DEVELOPMENT REVIEW BOARD  
SUPPLEMENTAL SUBMITTAL

PROJECT NO. PR-2020-004604

**To:** Jolene Wolfley and DRB Members, City of Albuquerque  
**From:** Michael Vos, AICP, Consensus Planning, Inc. *MV*  
**Date:** January 22, 2021  
**Re:** Allaso Vineyards DRB Comment Responses (PR-2020-004604)

This memo outlines the responses and changes made to the site plan for the Allaso Vineyards project based on the comments received and reviewed at the January 13, 2021 DRB meeting. The comments are numbered and followed by the response in italics.

**SOUTH ELEVATION (198'-0" LENGTH)**  
 5-11(E)(2)(a)(2.b) WINDOWS ON UPEER FLOORS - 75'-0" / 198'-0" = 37%  
 5-11(E)(2)(a)(2.d) WINDOWS WITH COVERING - 80'-8" / 198'-0" = 41%  
 5-11(E)(2)(a)(3.a) WALL PLANE PROJECTIONS - 119'-6" / 198'-0" = 60%

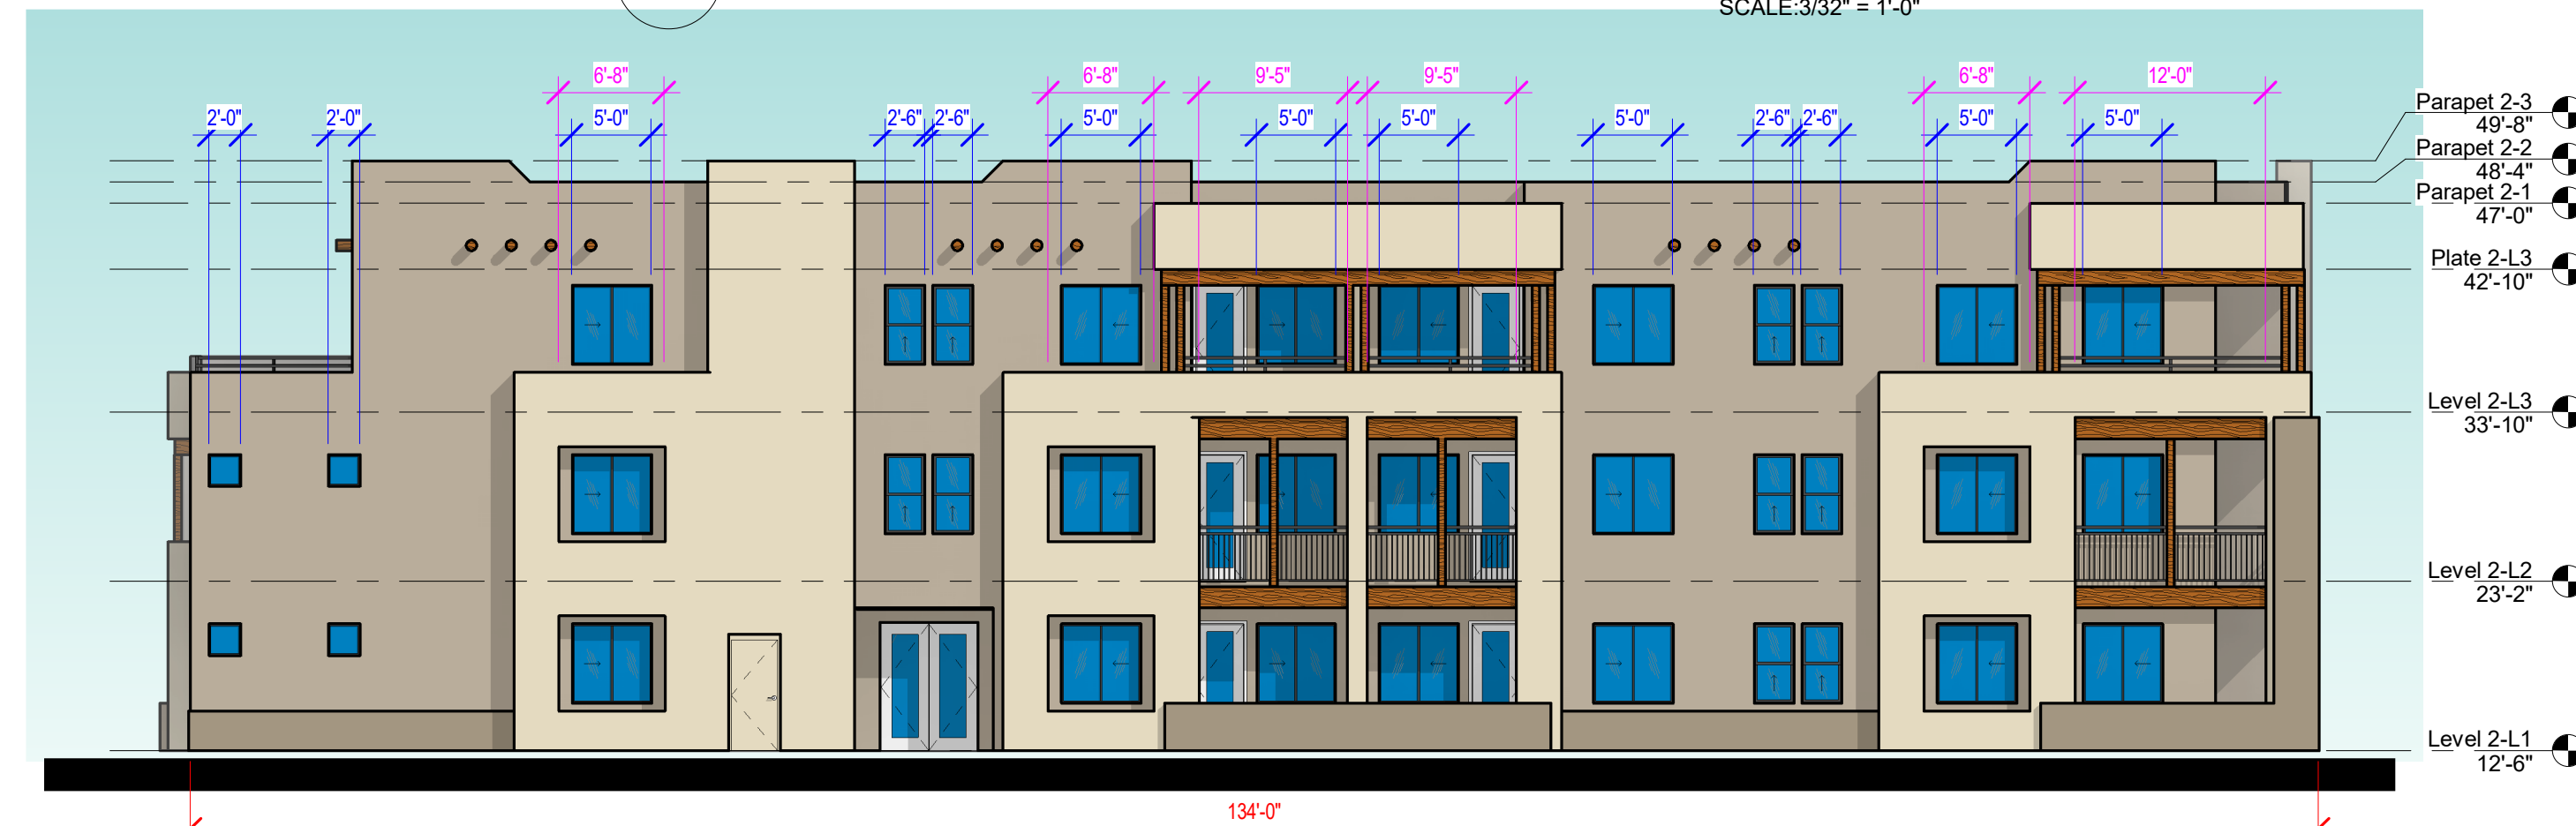
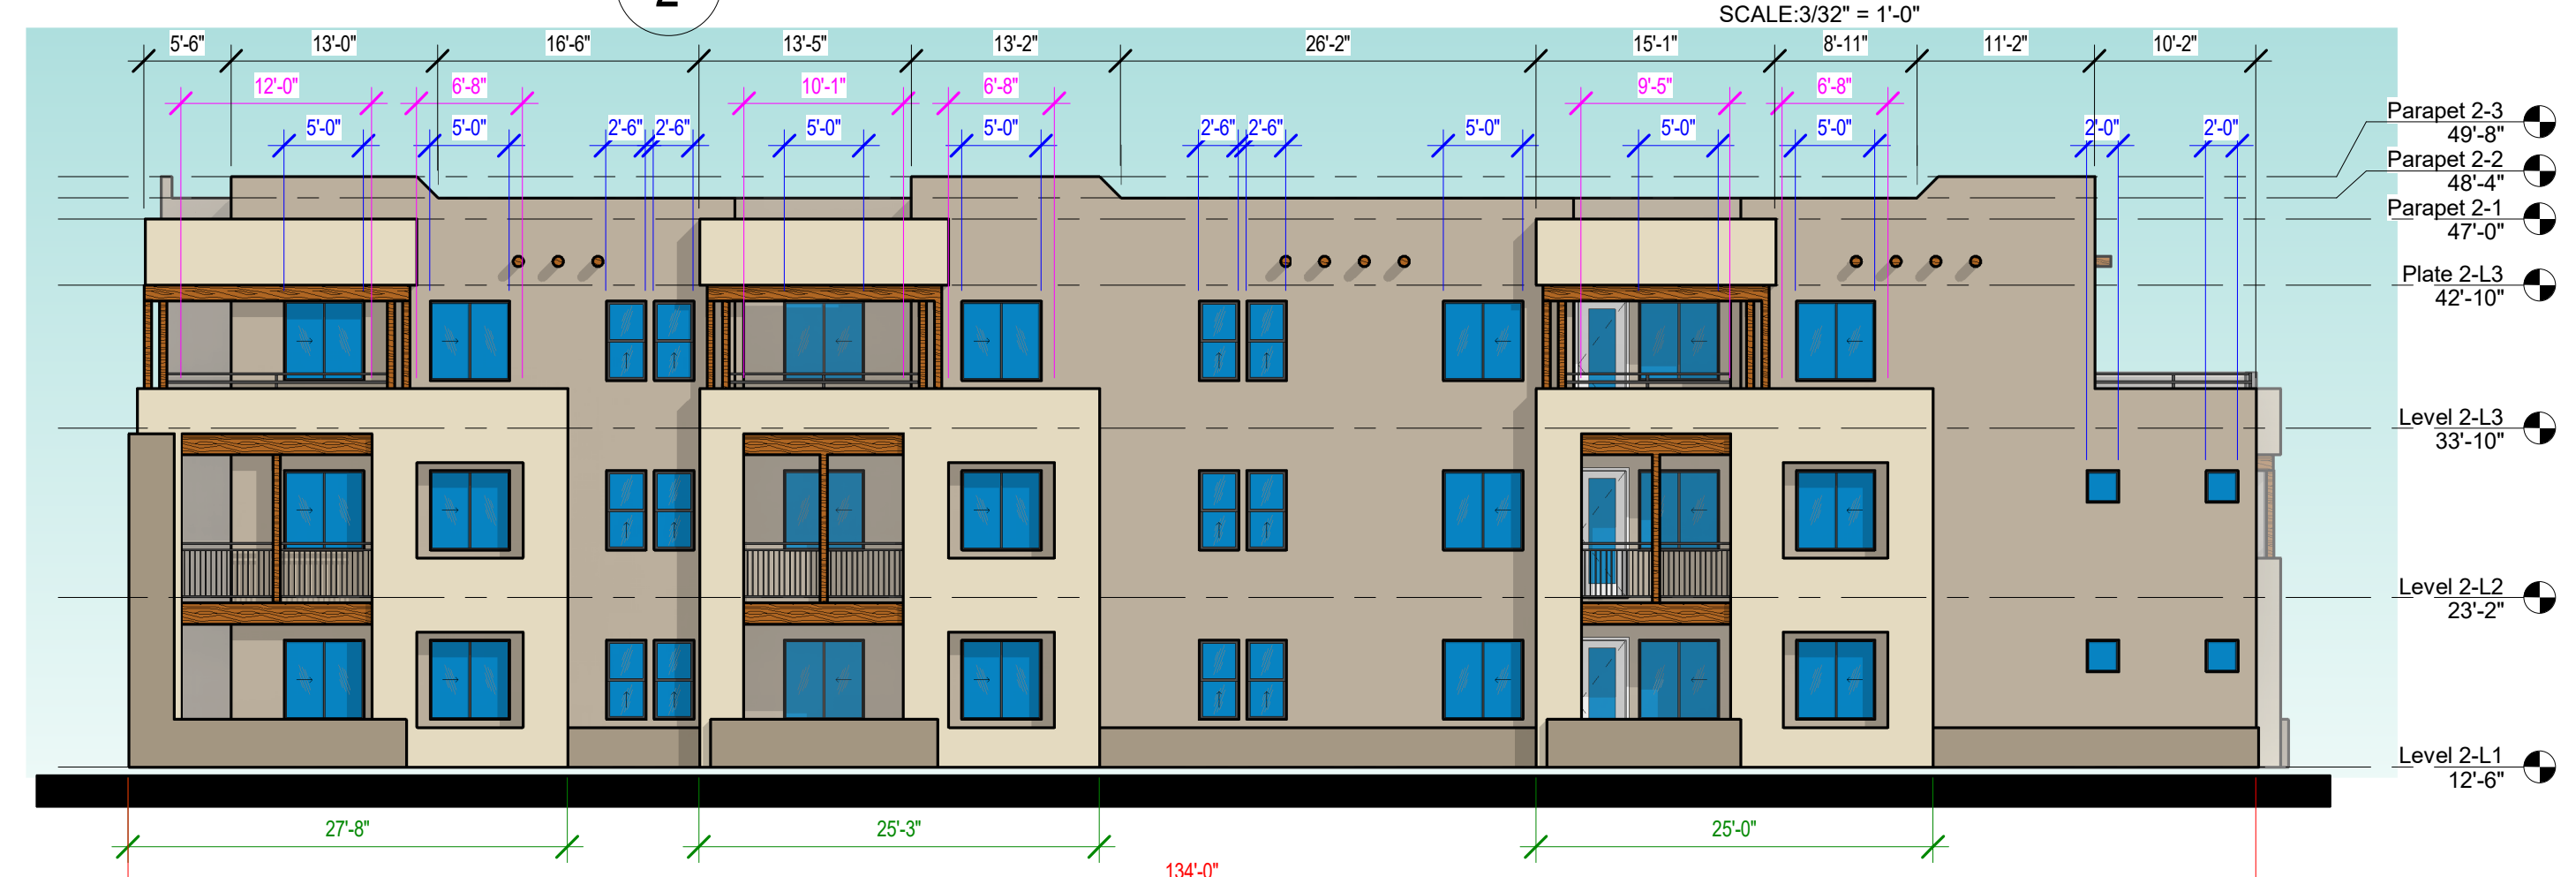
5. The applicant needs to confirm that the Façade Design requirements of 5-11(E)(2)(a) of the IDO are being met.
  - a. *The Applicant has reviewed the elevations for compliance with the design standards. Exhibits 1 and 2 in this resubmittal include dimensions and notes calculating each feature and its compliance on each required elevation. An additional stucco finish has been added along the ground floor to further define and provide a sense of human scale at the ground level as required by 5-11(E)(2)(a)1.*

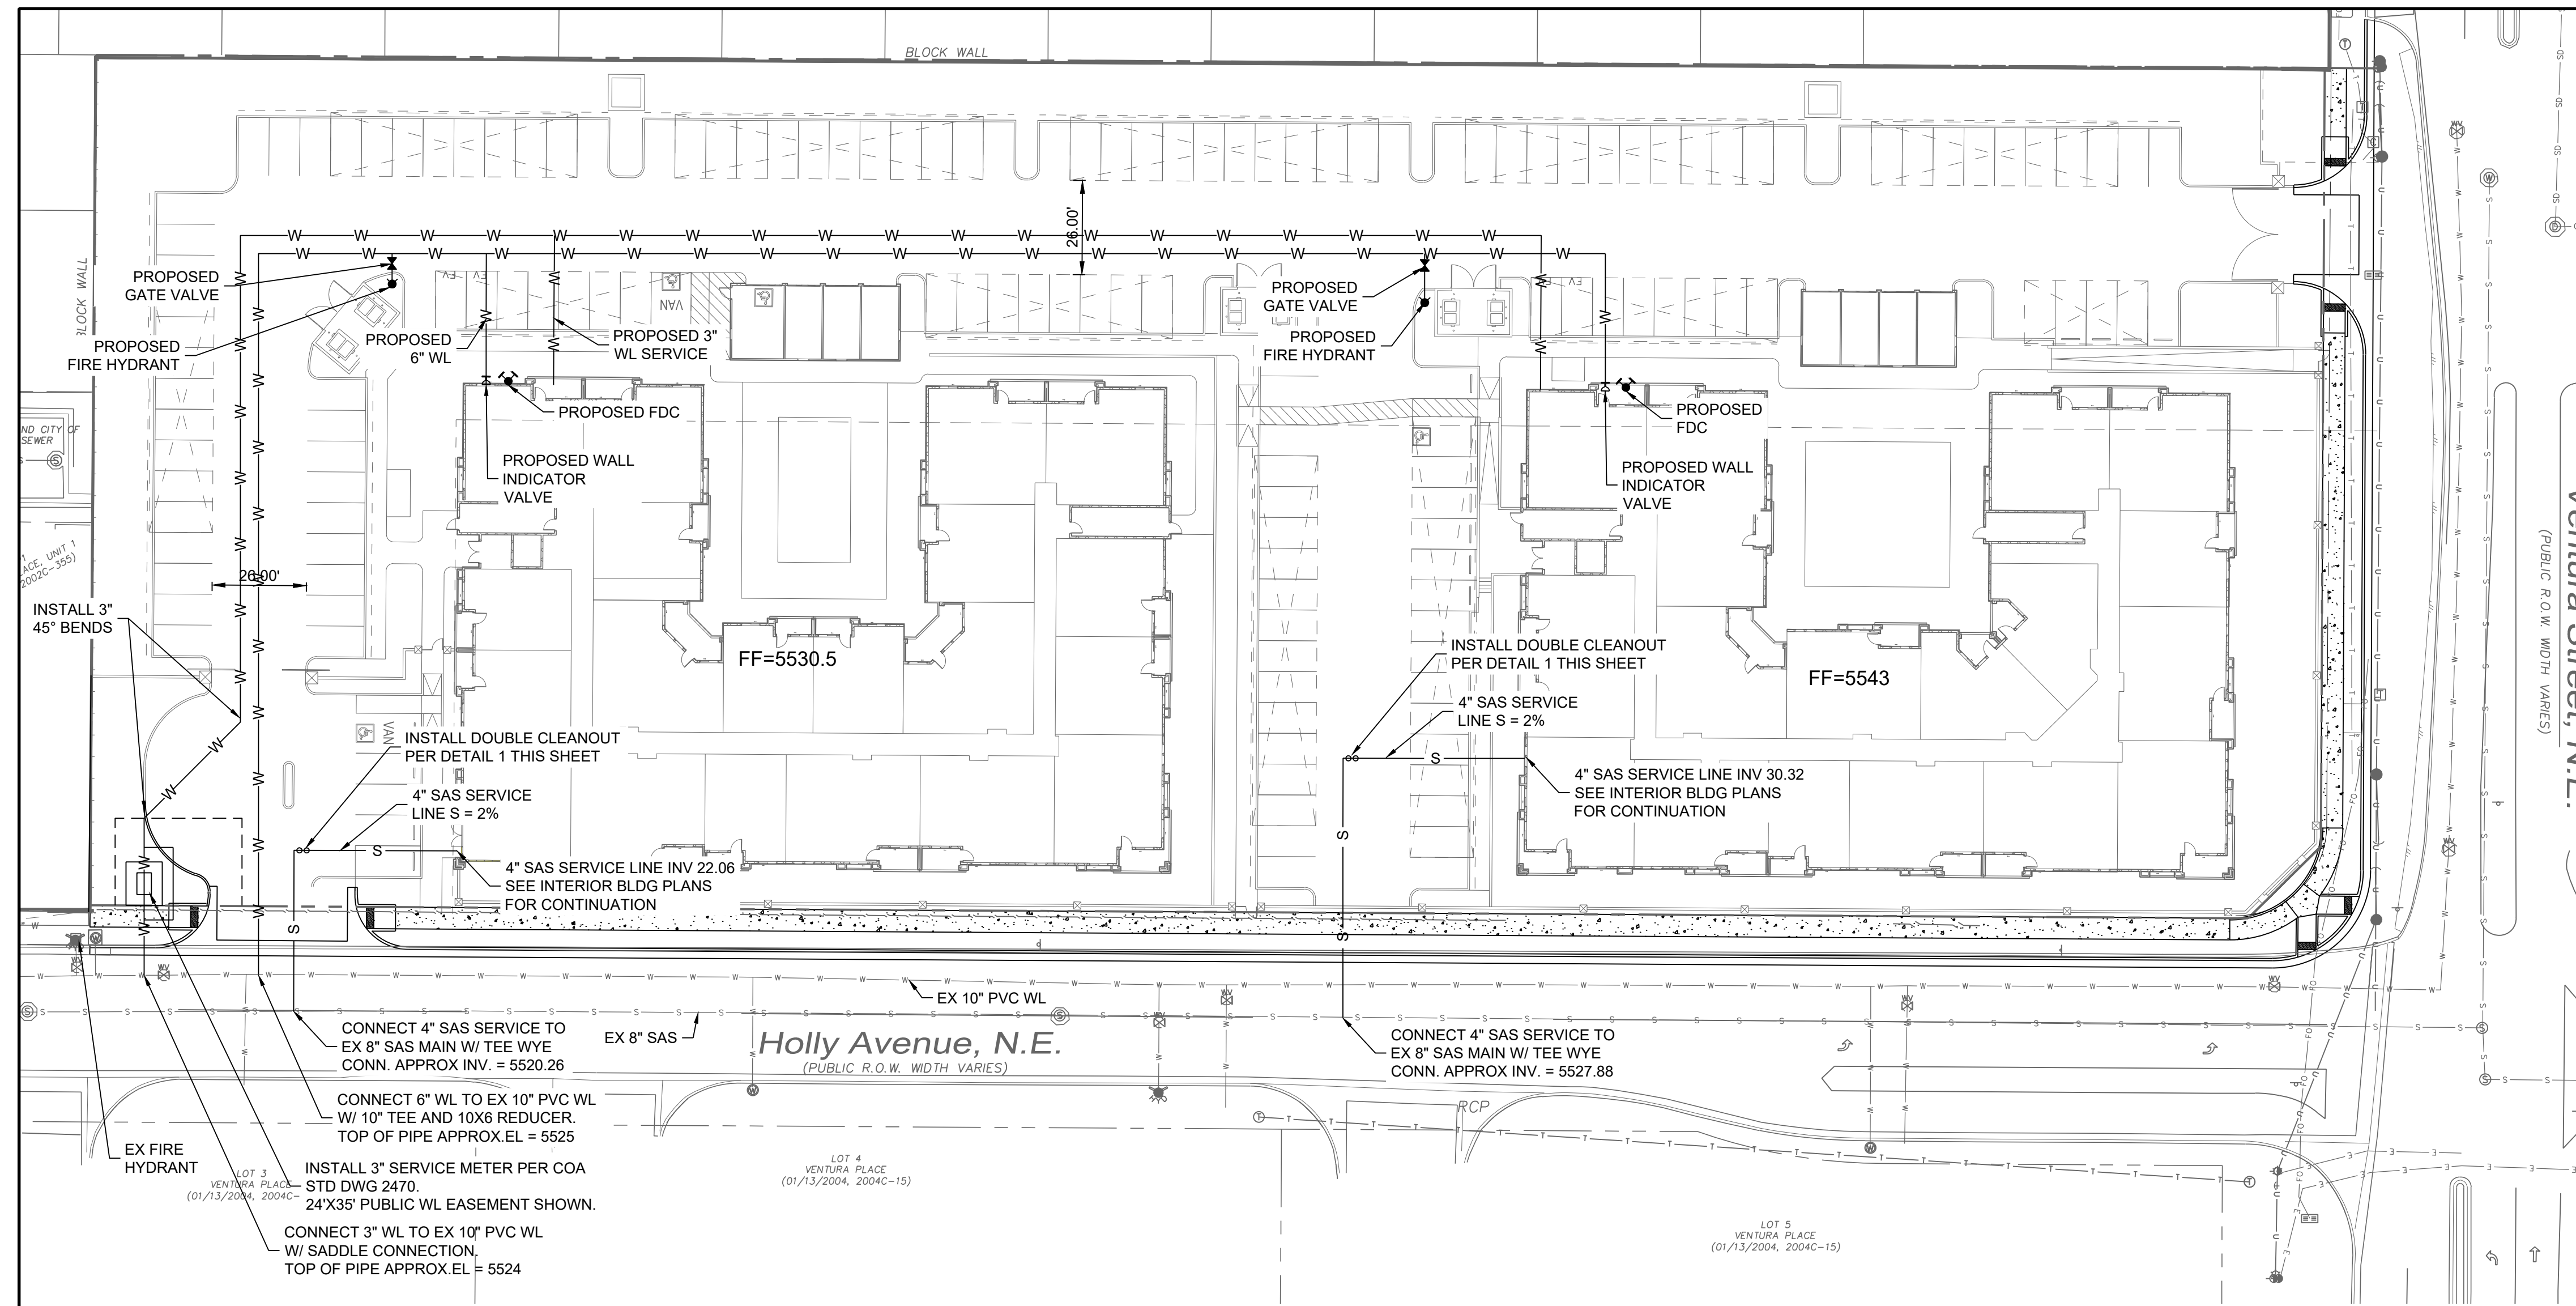
**2. Utility Plan**

- a. **The proposed FDC appears to connect to the proposed fire line. FDC connections connect directly to the building.**

- b. **Per the Cross Connection Ordinance, this development is considered a non-residential water customer as it is a multi-family dwelling of three (3) or more stories. All new non-residential premises shall have a backflow preventer. Please shown on plans.**

- c. **The onsite private waterline loops to the public system. The DPM does not allow for looping of a private line into the public system. Please provide separate fire lines for the private fire hydrant and fire suppression systems.**

FDC connection revised.

Note on plans describes backflow preventer to be internal to the buildings.

The proposed line connection has been removed from Ventura St. to eliminate the looped system.
